CITY OF ALBUQUERQUE

June 24, 2021

**Re: Bueno Foods 2001 4th St SW
Erosion and Sediment Control Plan
Engineer's Stamp Date 6/24/2021 (L14E001A)**

NO.	DATE	DESCRIPTION
0	04/09/2021	ISSUED FOR PERMIT REVIEW
1	09/01/2021	REVISED PER CITY OF ALBUQUERQUE COMMENTS
JOB NUMBER 20002500 SCALE @ 24"x36" As indicated		
DRAWN BY CZW DATE ISSUED 8/23/2021		
SHEET NAME EROSION AND SEDIMENT CONTROL PLAN		
REVISION SHEET C-014

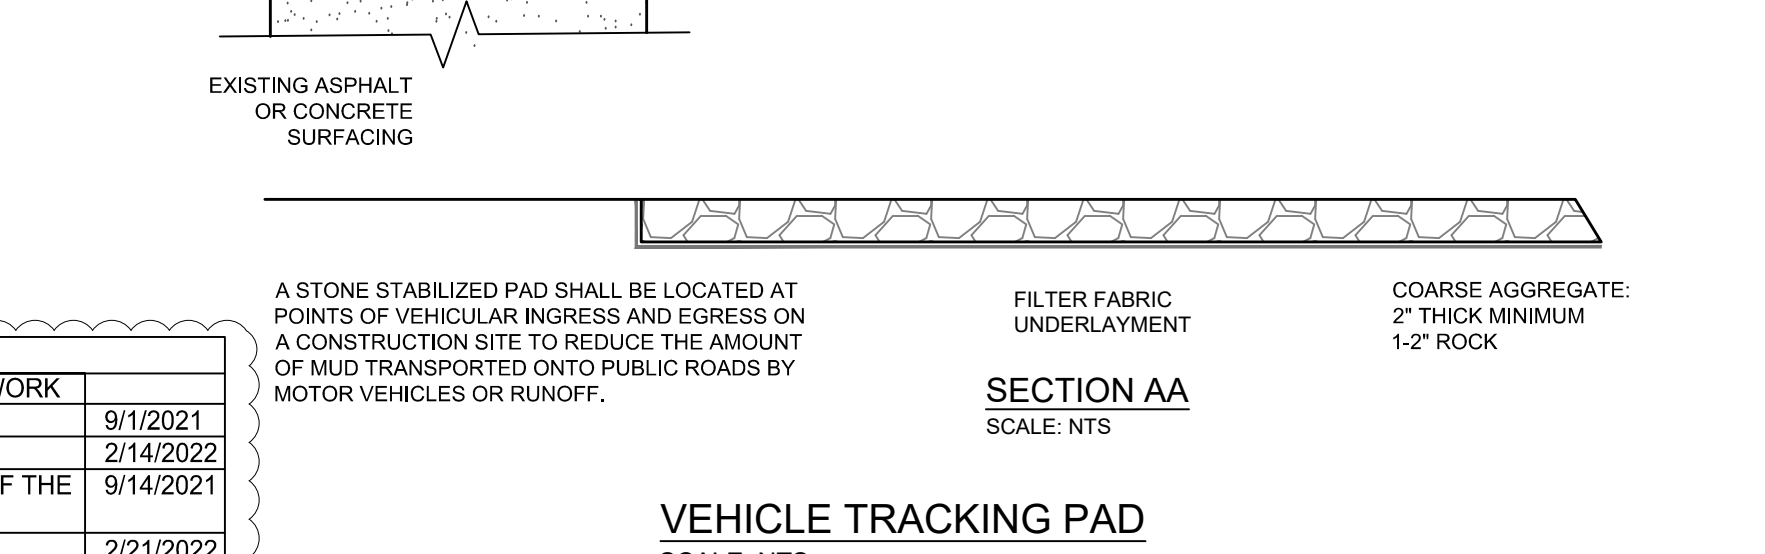
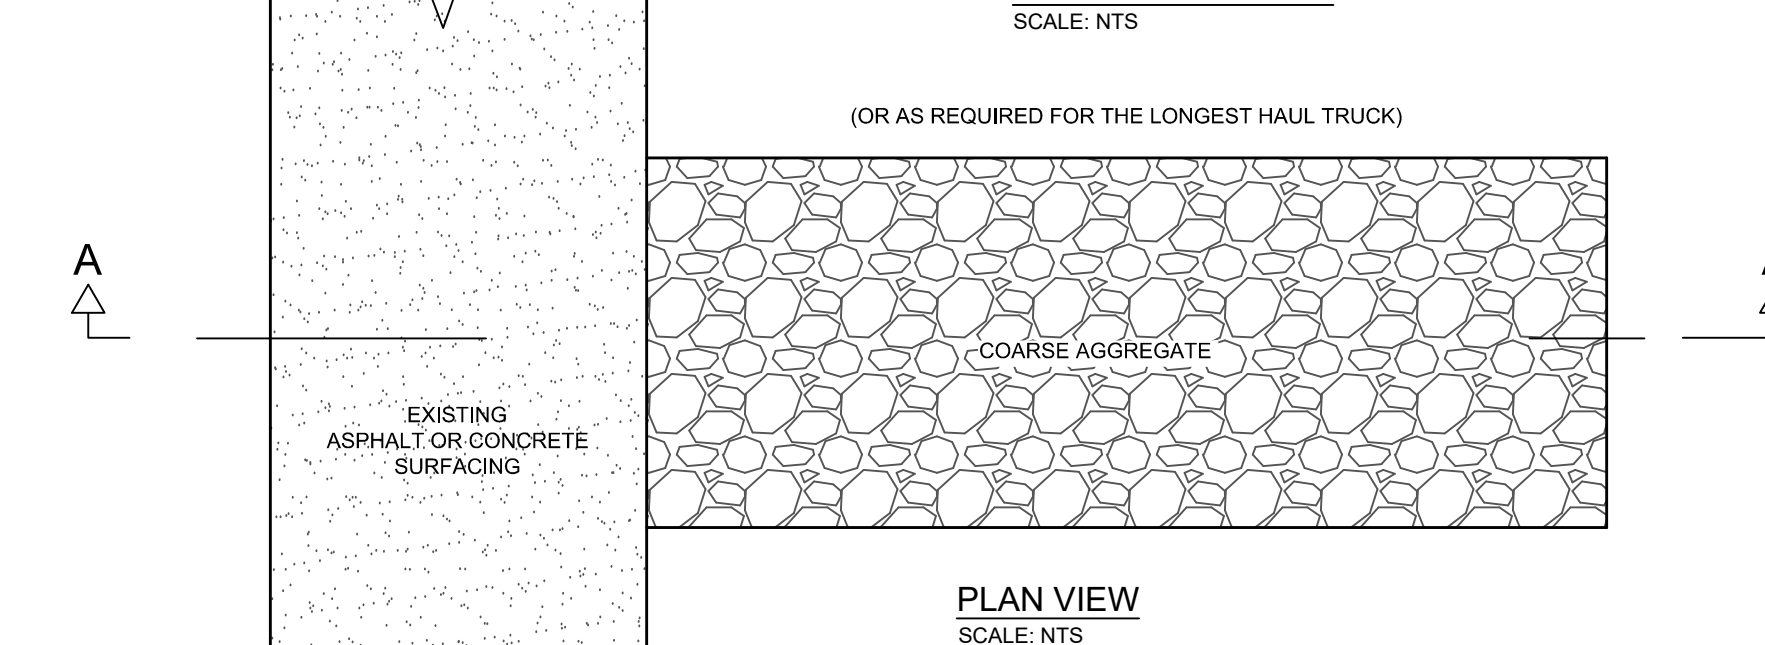
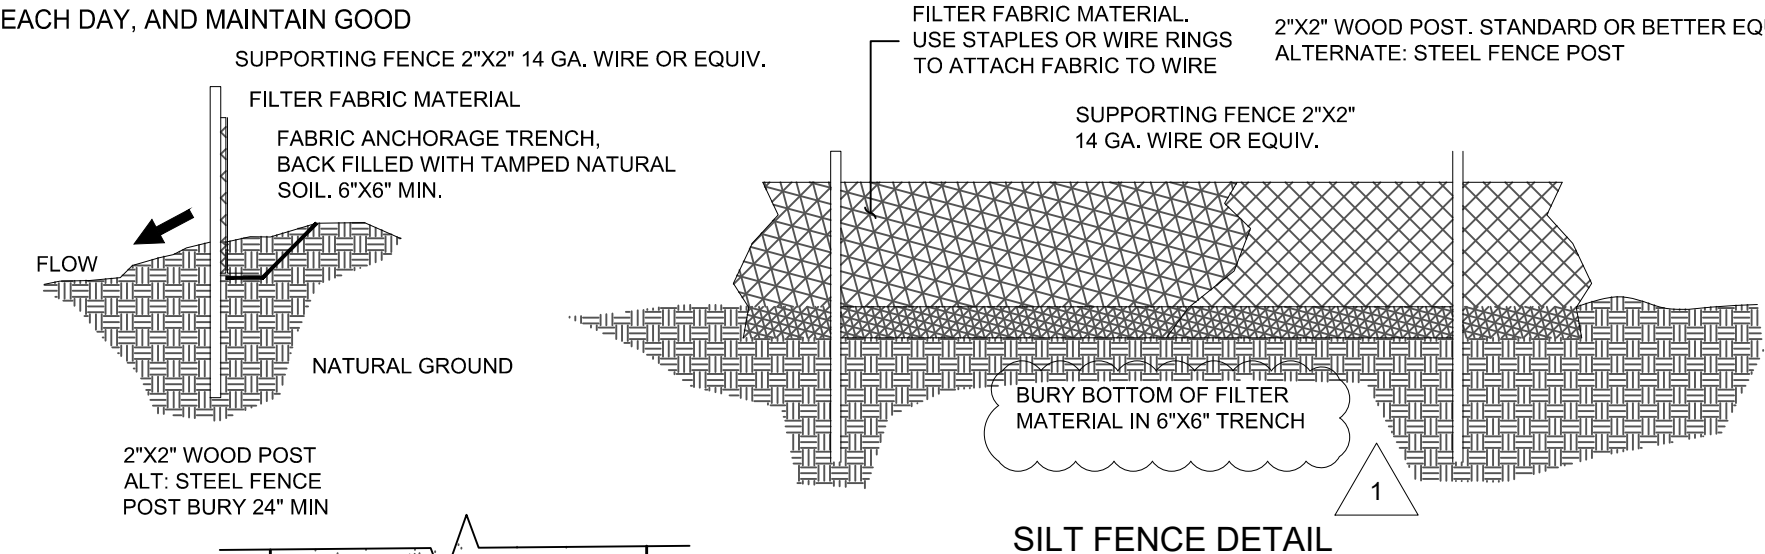
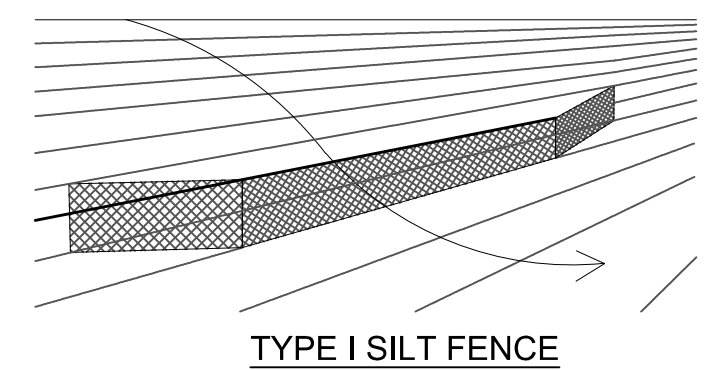
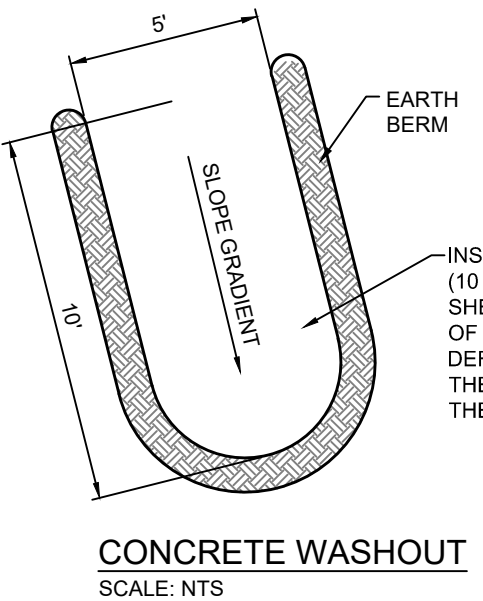
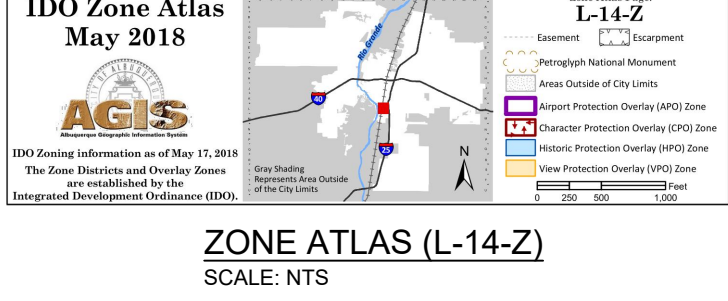
2. List operators on the plan, including name, phone #, and e-mail address. Include the developer/property owner's representative authorized to make changes to contract documents, plans, and specifications per CGP 7.2.1. If there are multiple operators, describe the area of control and where the SWPPP for each will be located;

3. Identify stormwater team members responsible for sediment removal, BMP maintenance, and inspections on the plan, including name, phone #, and e-mail address (CGP 7.2.2). Provide the stormwater team for each operator;

4. Describe the nature and extent of construction activities for each operator (CGP 7.2.2.), including a) nature of construction activities, b) size of the property, c) size of disturbed area, d) description of construction support activities, e) size of maximum disturbed area, and f) Project Schedule. The schedule shows Stabilization in the early Fall, which is unlikely to satisfy the EPA's Final Stabilization Criteria by February unless the Stabilization consists of aggregate or rock landscaping.

6. Silt Fence note # 4 should say 2' height instead of 16". Note #9 should say 50% instead of 75%. The embedment trench should be 6"x6" on the detail.

7. The word “hosed” in General Note # 4 probably should be deleted. Sediment in the street is to be picked up and never hosed. Hosing the track-out pad is not a good idea unless you specify where the wash water will go, like into a sediment trap next to the pad. The wash water isn’t allowed in the street.
8. Update the engineer’s stamp date each time the plan is changed.

L101

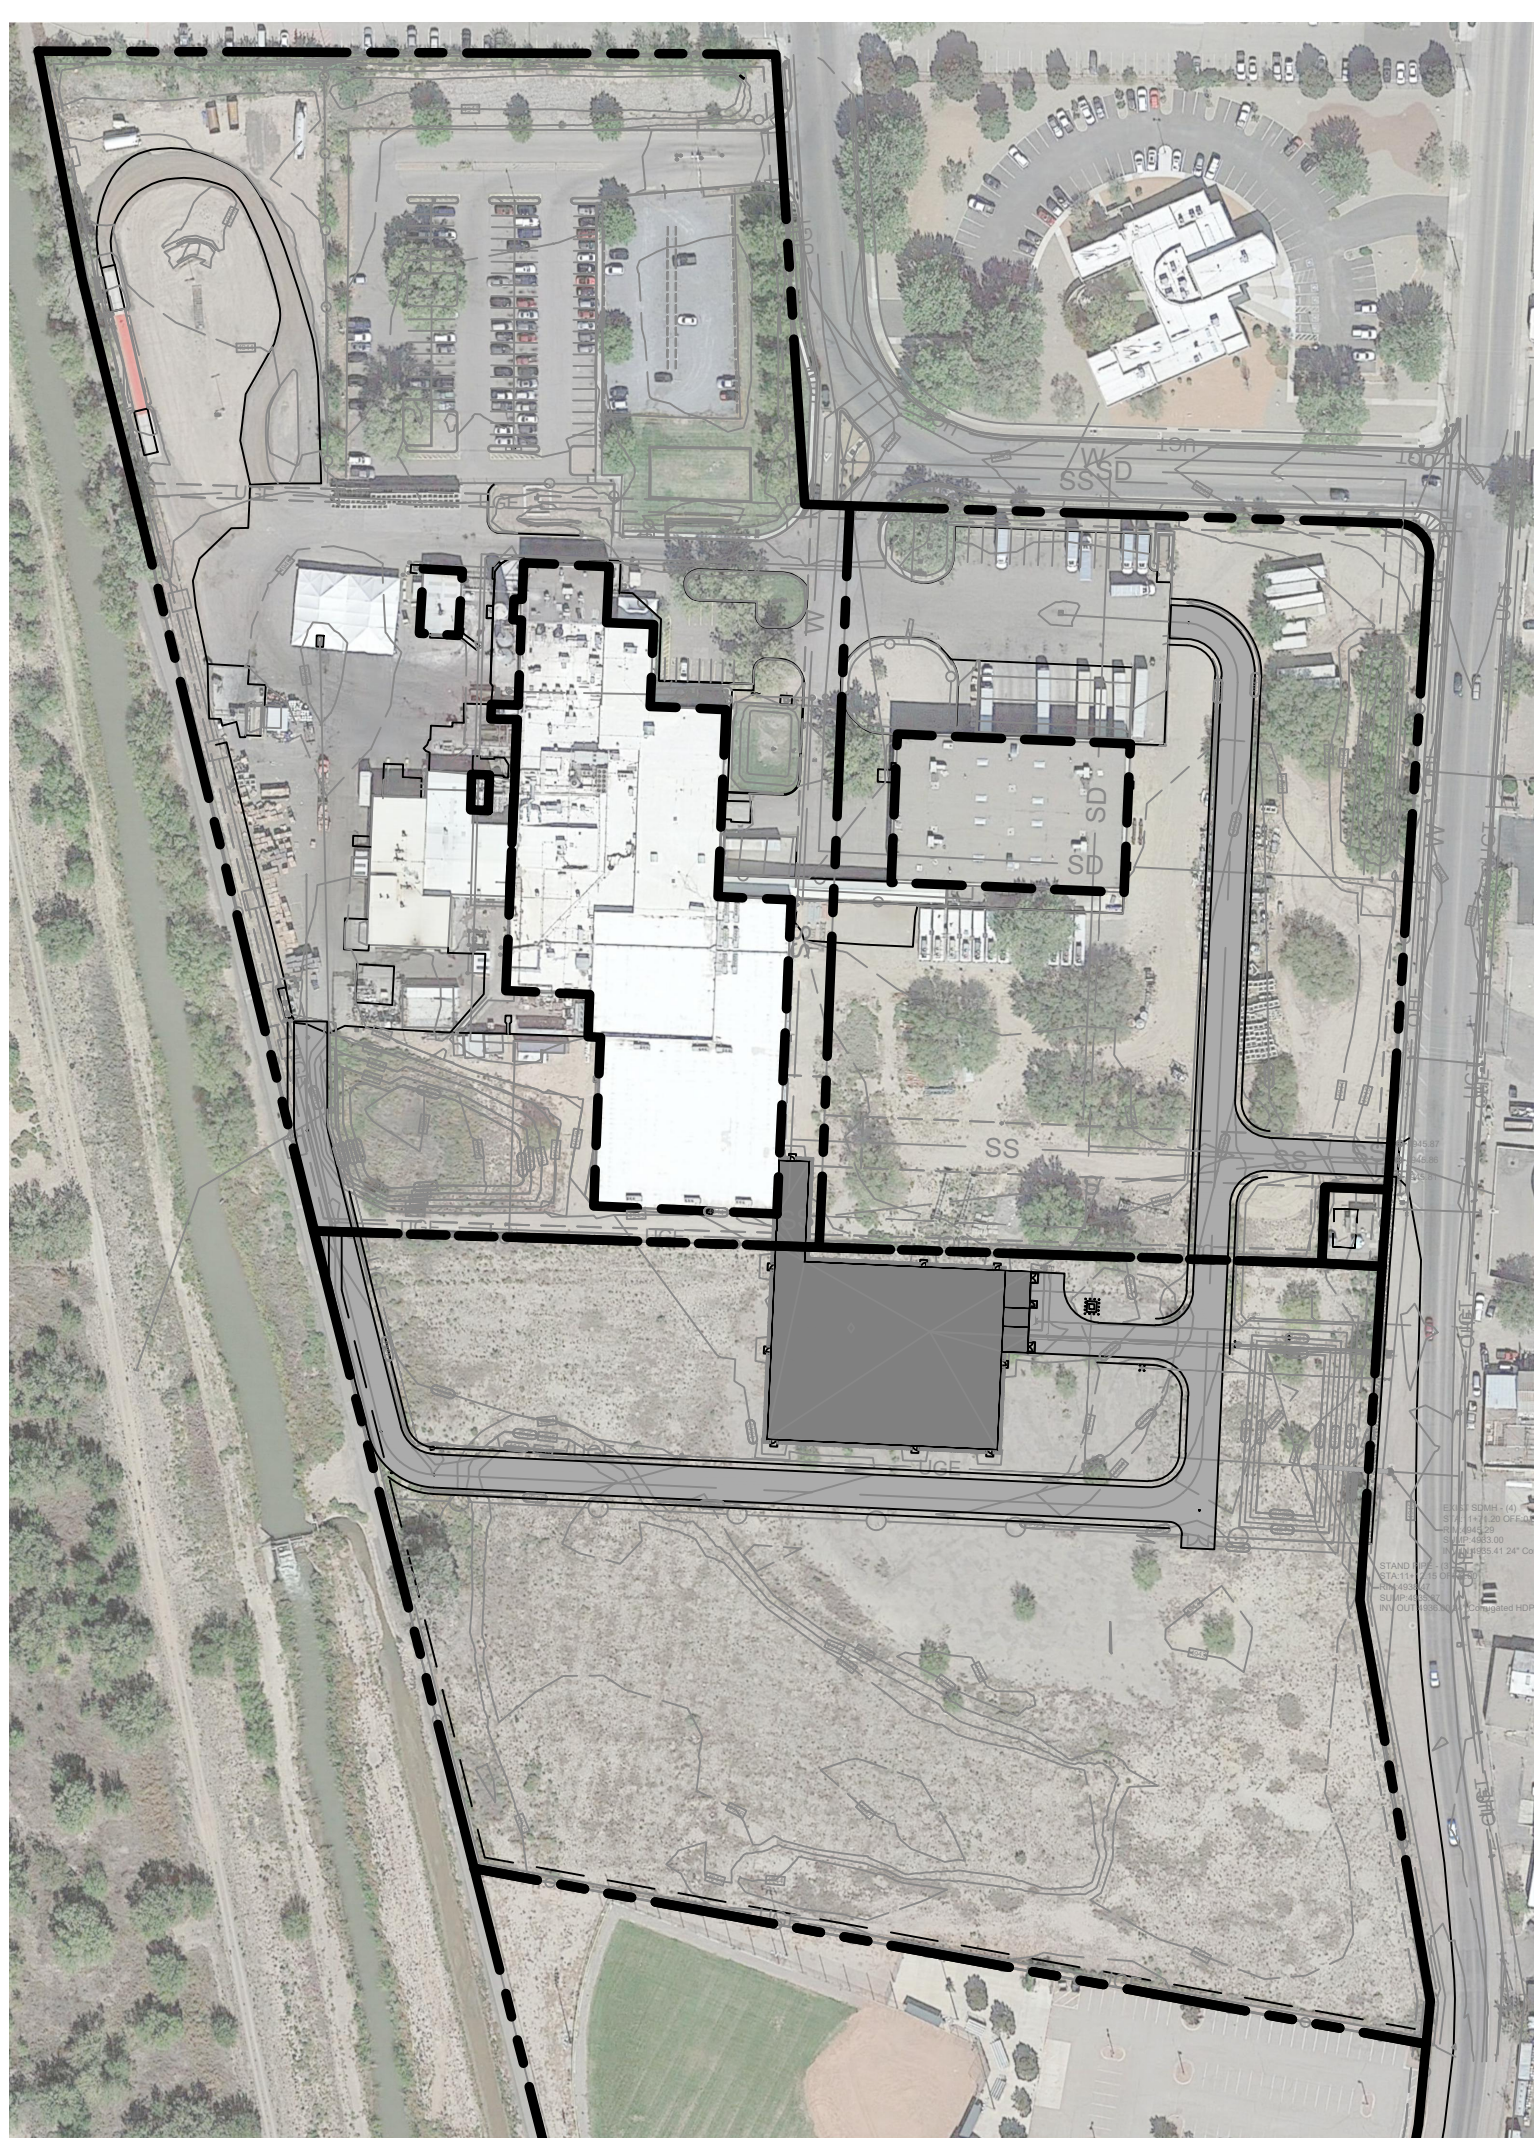
5. Stabilization measures (CGP 7.2.6.b.vi), including a) **Specific** vegetative and non-vegetative practices, b) deadlines, c) beginning and ending dates of the seasonably dry period, d) procedure to comply with The Weed Removal Ordinance (§ 9-8-1). The landscape plan can be used to satisfy this requirement and should be included in the SWPPP and the ESC Plan submittal;
